PLANNING CONSULTATION RESPONSE

Application No	2025/0610
Proposal	Development of five residential dwellings and associated infrastructure
Address	Vernon House, Yews Lane, Kendray, Barnsley, S70 3LJ
Date of Consultation Reply	12 th August 2025
Consultee	Highways DC

Visibility splays and proposed access arrangements

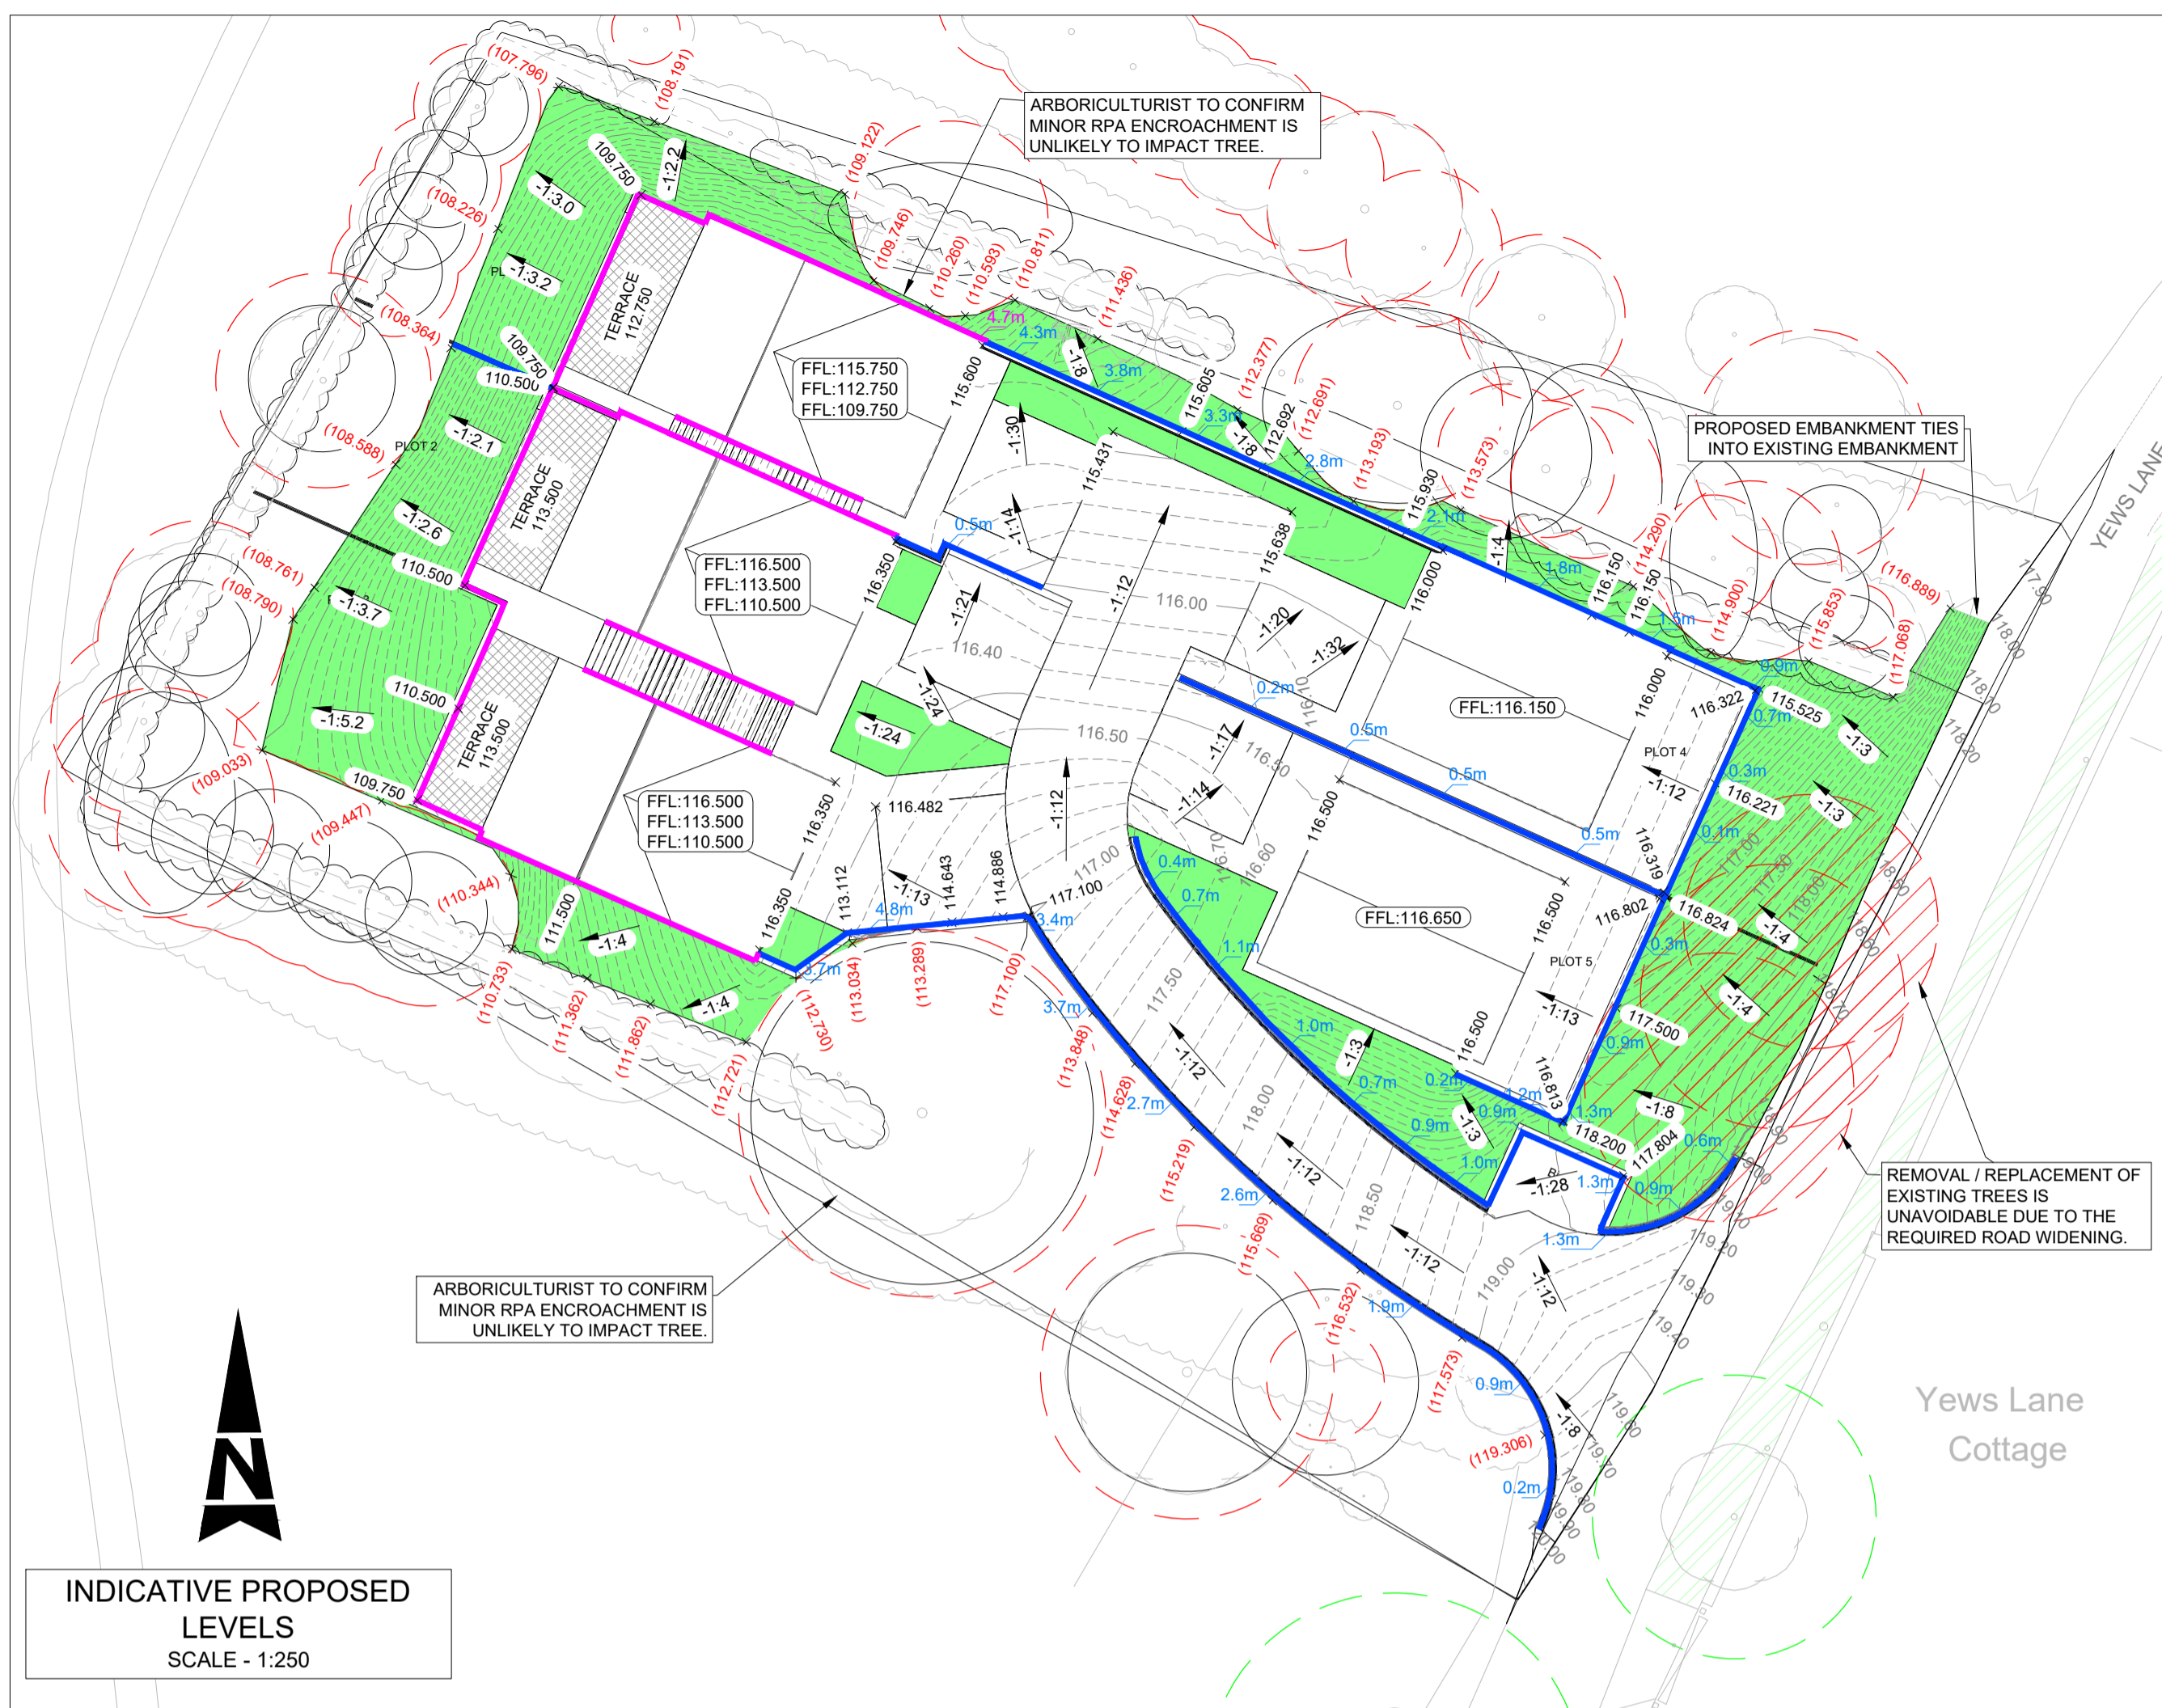
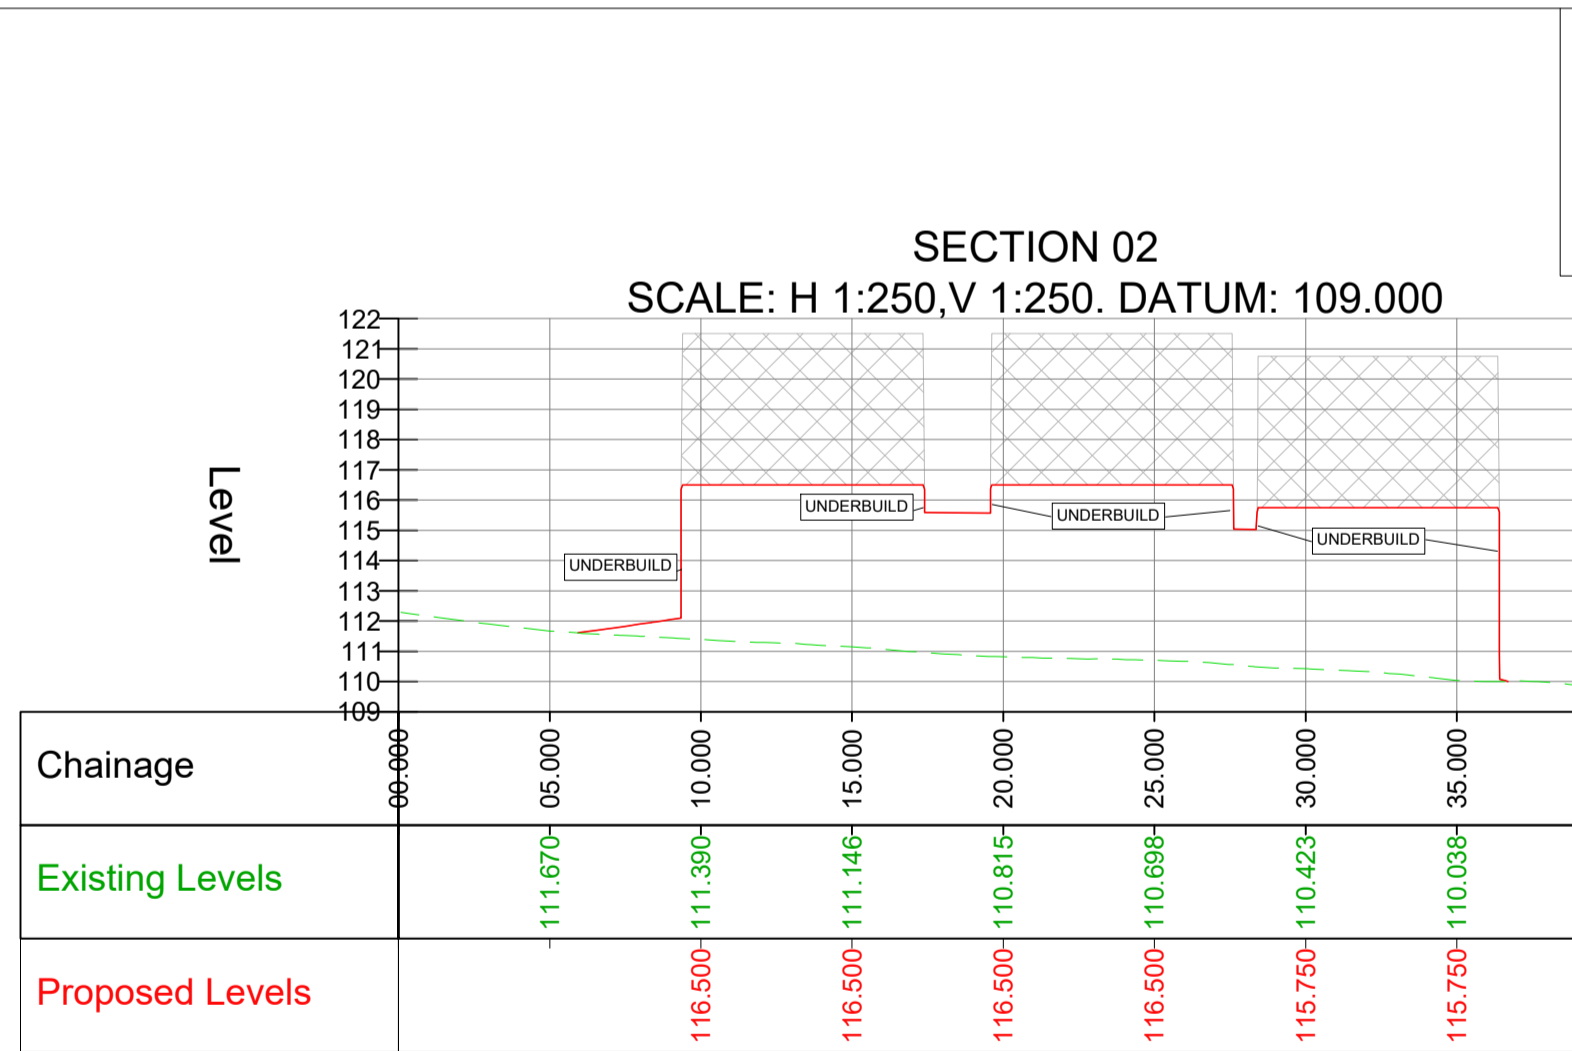
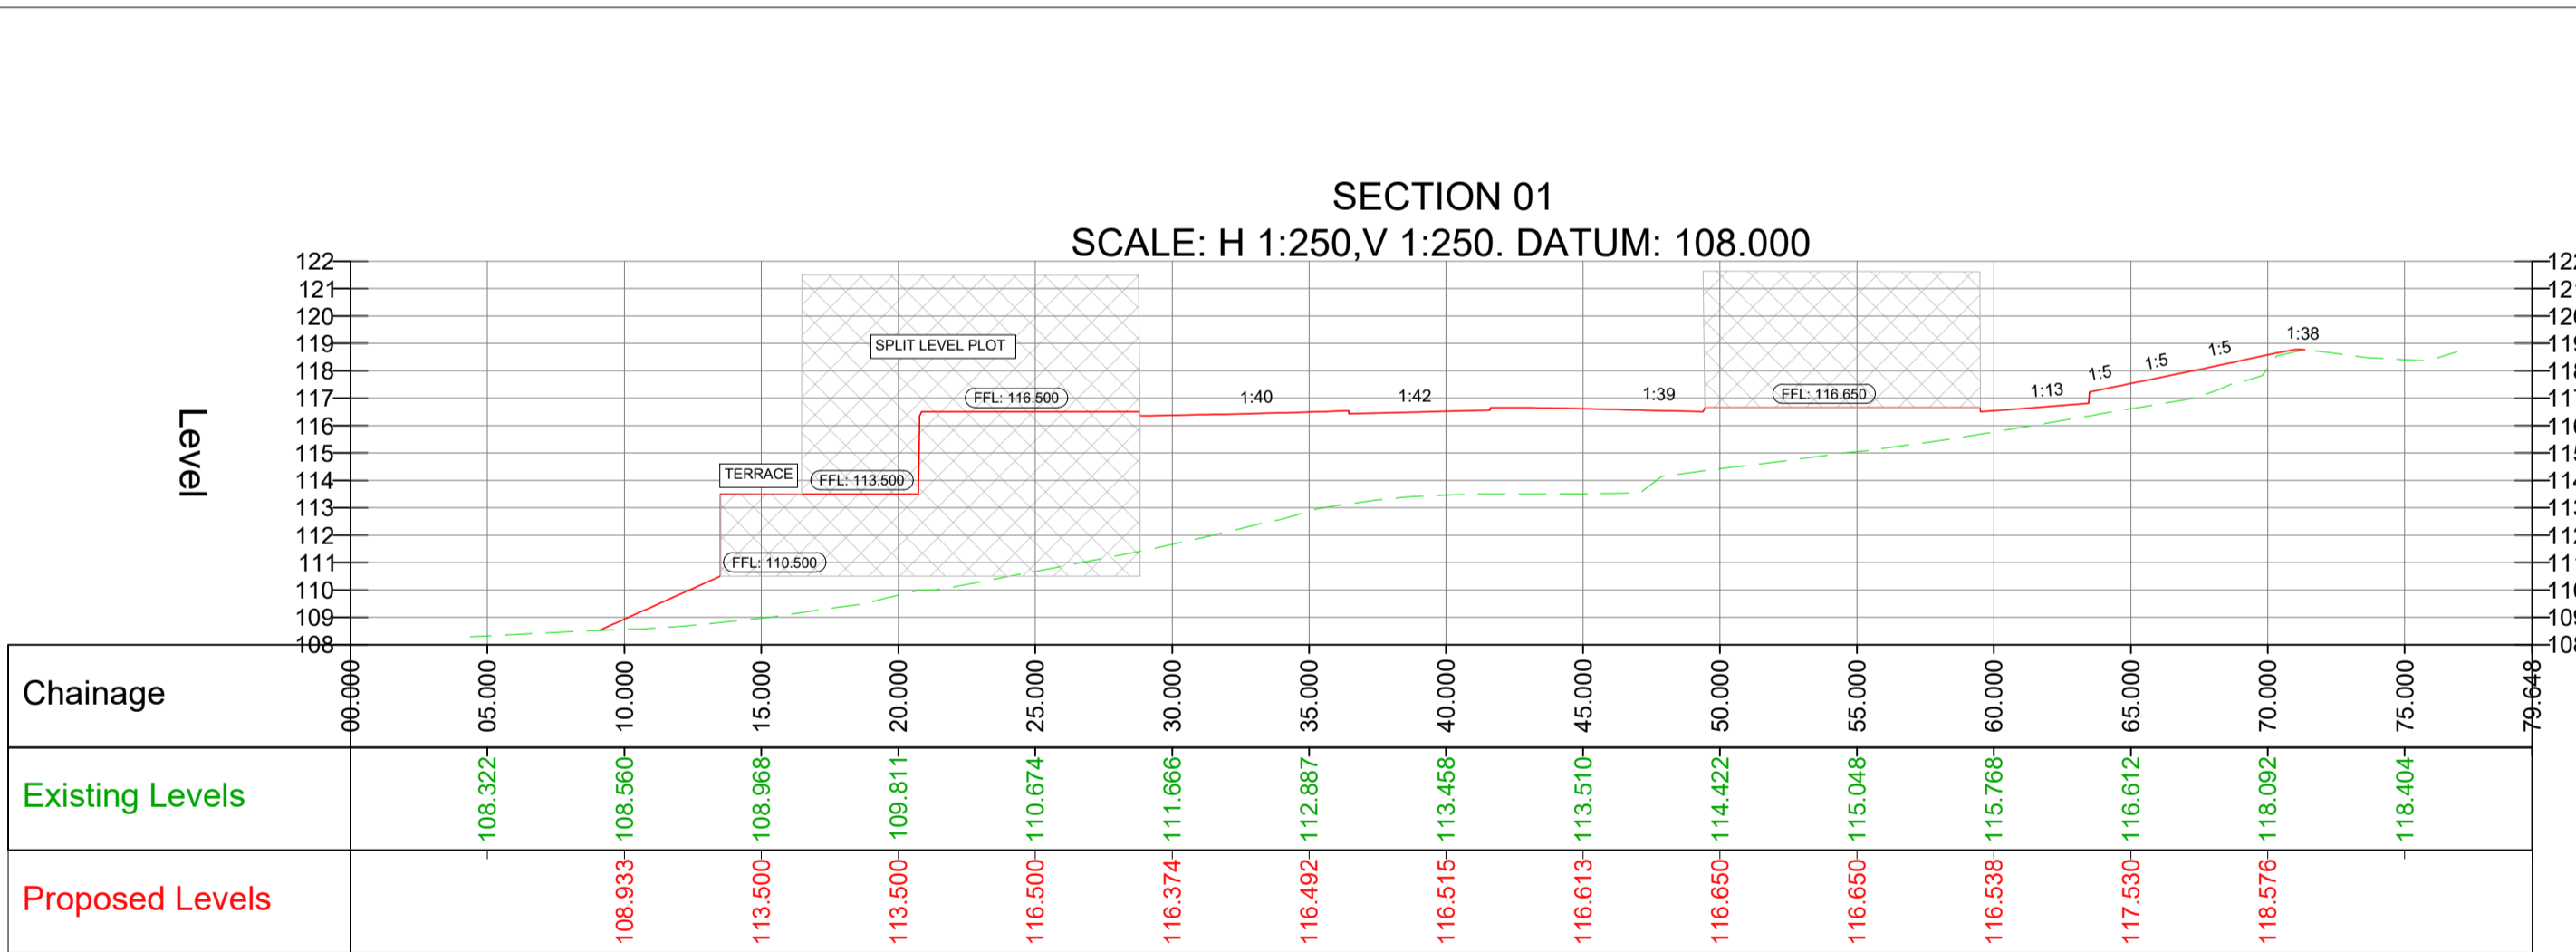
The report states that these sight lines are achievable. However, the 'Visibility Splays from Site Access' drawing contained within Appendix D includes sight lines that have the 'x' distance incorrectly shown. The 2.4m 'x' distance must be measured back from the edge of the proposed carriageway, not the existing edge.

It is likely that the proposed bin store would impede visibility when the sight lines are drawn with the correct 'x' distance.

Also, it is noted that the sight line to the right (South) encroaches into land outside of the red line boundary and therefore presumably outside the control of the applicant; as such, the provision of the sight line could not be ensured.

The proposed site access is shown to have a gradient of 1:8, this exceeds the maximum permitted gradient of 1:12.
